City of Portland, Maine - Building or Use Permit Application

Permit No: 02-0178
 Issue Date: APR 1 2002
 CITY OF PORTLAND

Past Use: Vacant	Proposed Use: New 28' x 38' Single Family with 24' x 24' two car garage, 12' x 12' mudroom and 5' x 8' open porch.	Permit Fee: \$863.00	Cost of Work: \$120,000.00	CEO District: 3
---------------------	---	-------------------------	-------------------------------	--------------------

ADDITIONAL DETAILS PER REQUEST OF TAMMY MUNSON 3/28/02

Dwg# 5.0	Project Residence	Hildreth & White P.O. Box 433 Portland, Maine 04104 (207) 772-0657
	Title Sections & Details	Drawn By: Total Perspective 2 Trackside Drive Kennebunk, Maine 04043 (207) 985-1639
HW-2-02 PLN064.1	Date 2-15-02

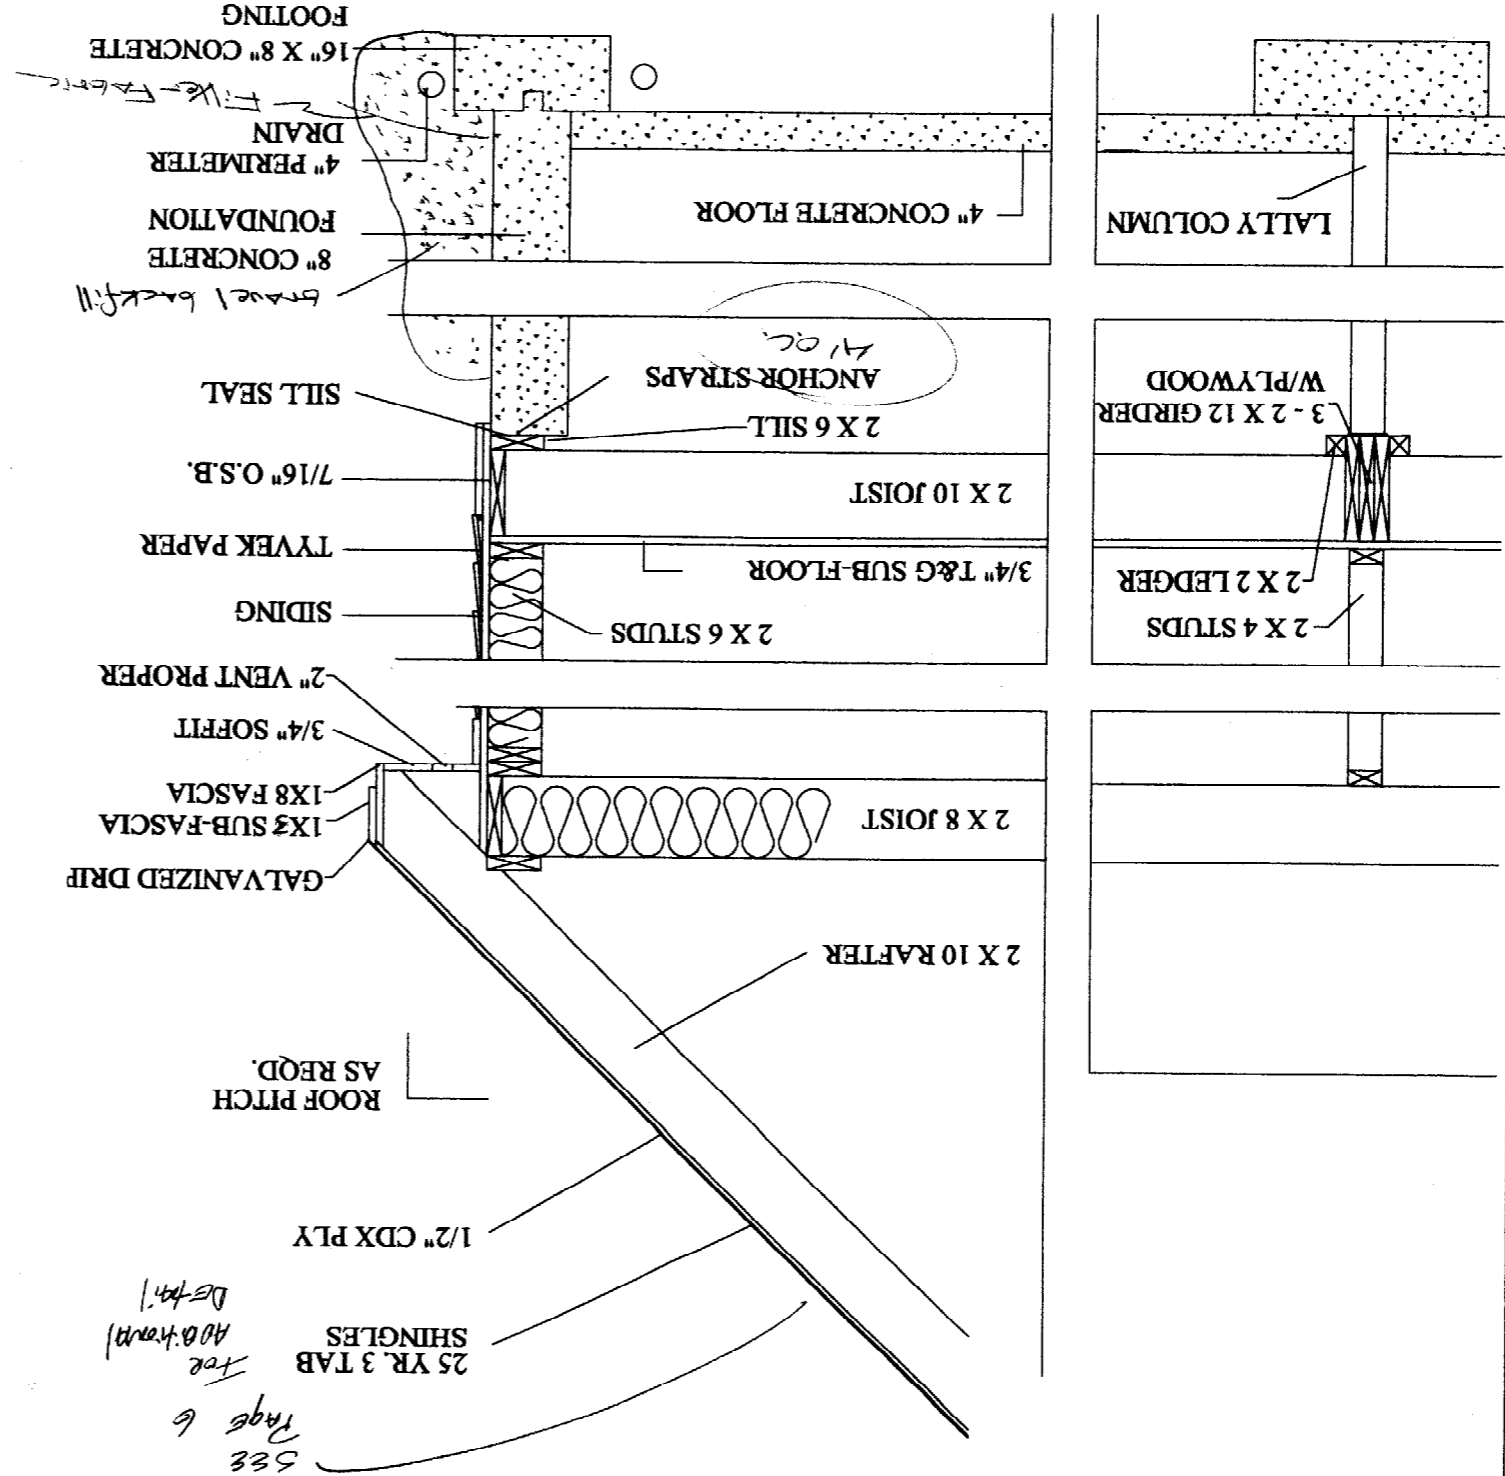
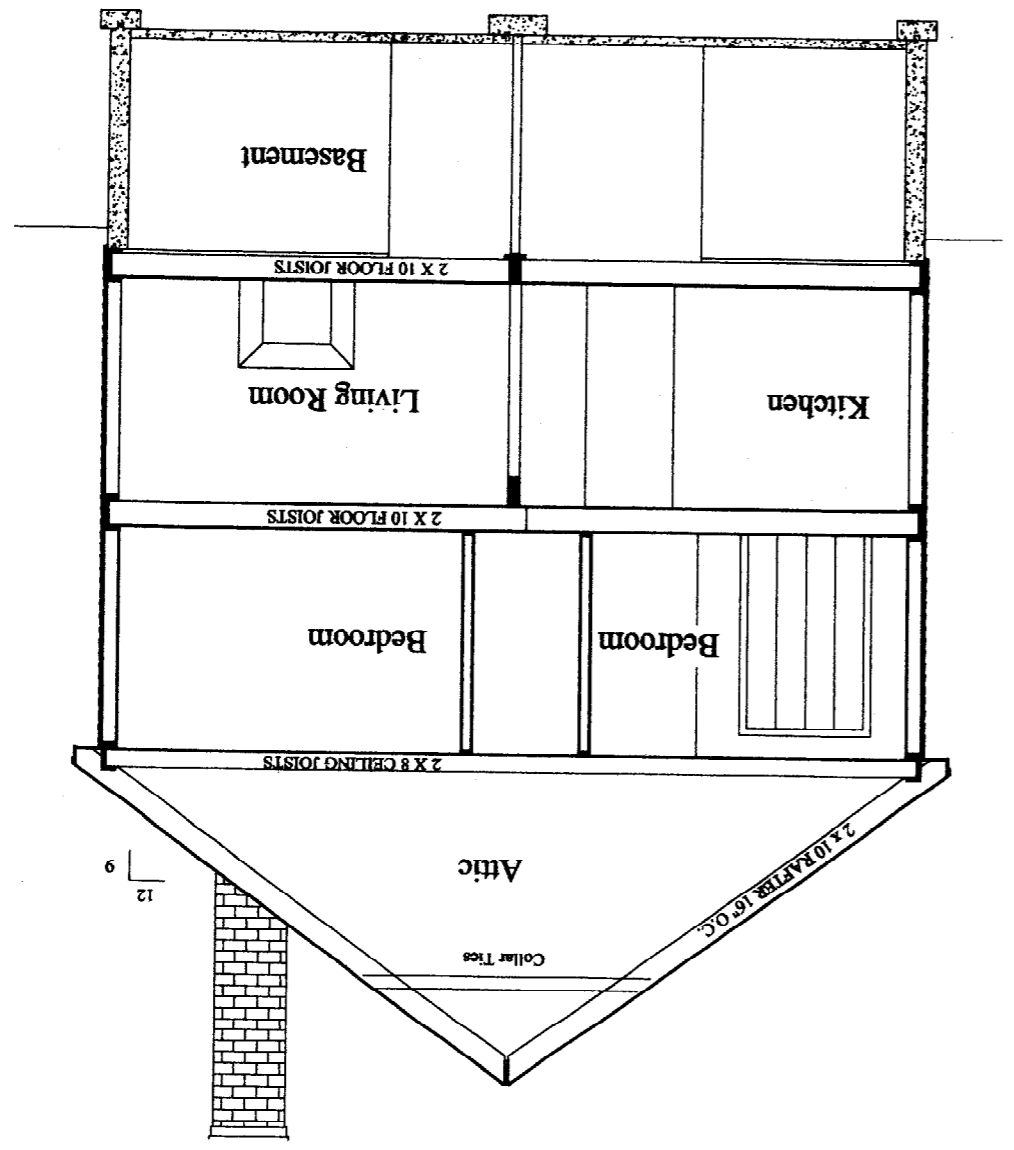
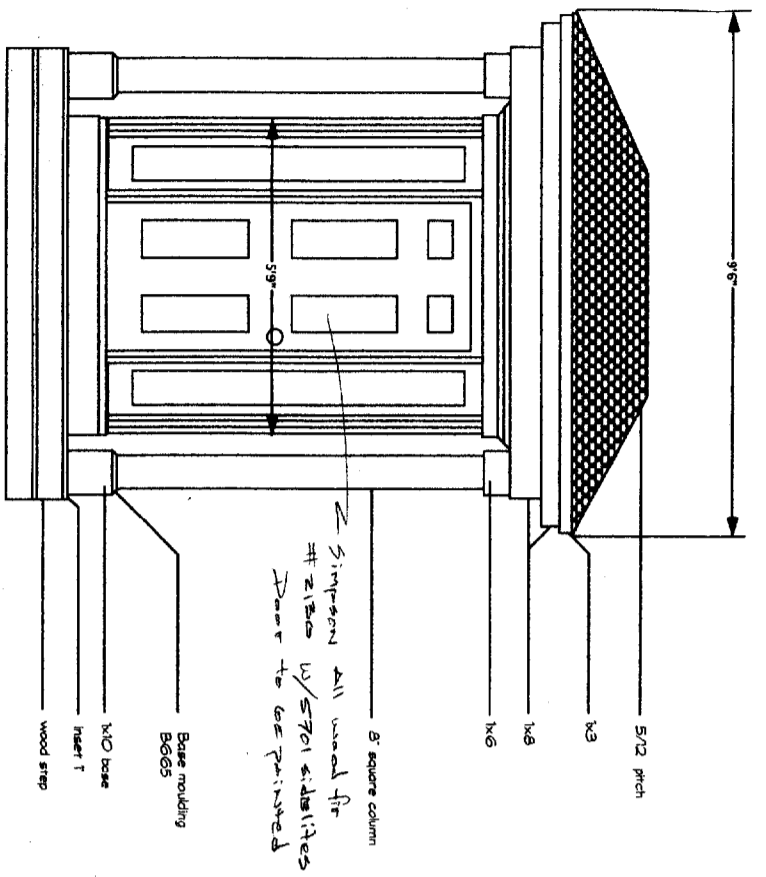
- ✓1. Show Headers: see revised window schedule page 6
- ✓2. Anchor strap spacing: see revised cross section page 5
- ✓3. Filter fabric/gravel backfill: see revised cross section page 5
- ✓4. Stair detail: see new stair detail page 7
- ✓5. Portico framing detail: see new framing detail page 7
- ✓6. Girder column spacing: see revised foundation plan page 4
- ✓7. Larger pad column pad: see revised cross section page 4
- ✓8. Scuttle hole: see revised 2nd floor plan page 3
- ✓9. Label smoke detectors see new item page 3
- ✓10. Label egress windows: see revised window schedule page 6
- ✓11. Breezeway framing: see new framing detail page 7
- ✓12. garage framing: see new framing detail page 7

Stair detail

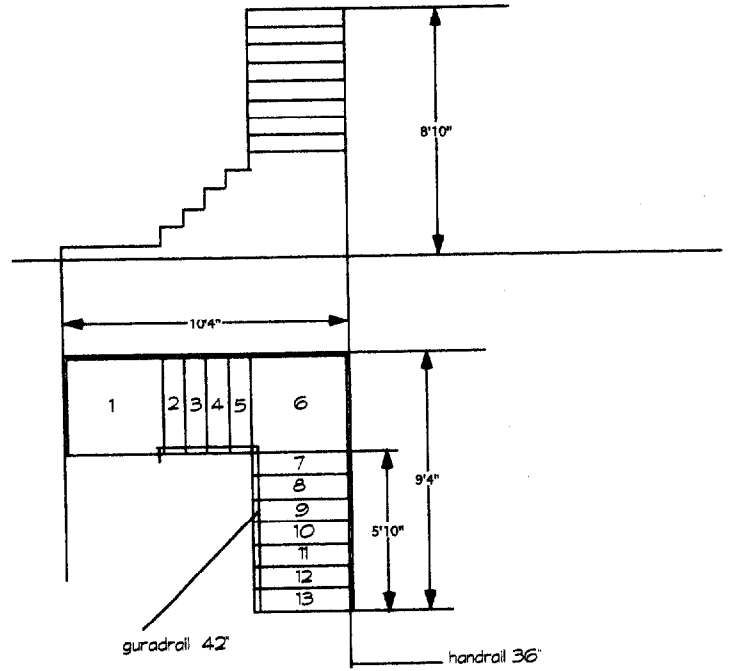
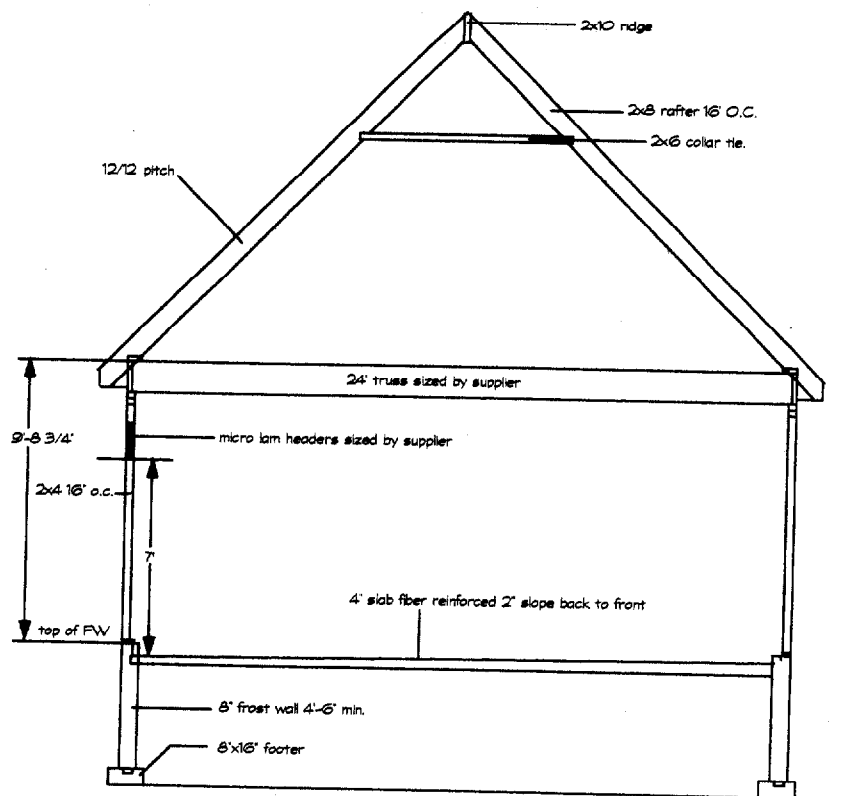
~~Chair~~ Nosing on stairs? - Will have nosing
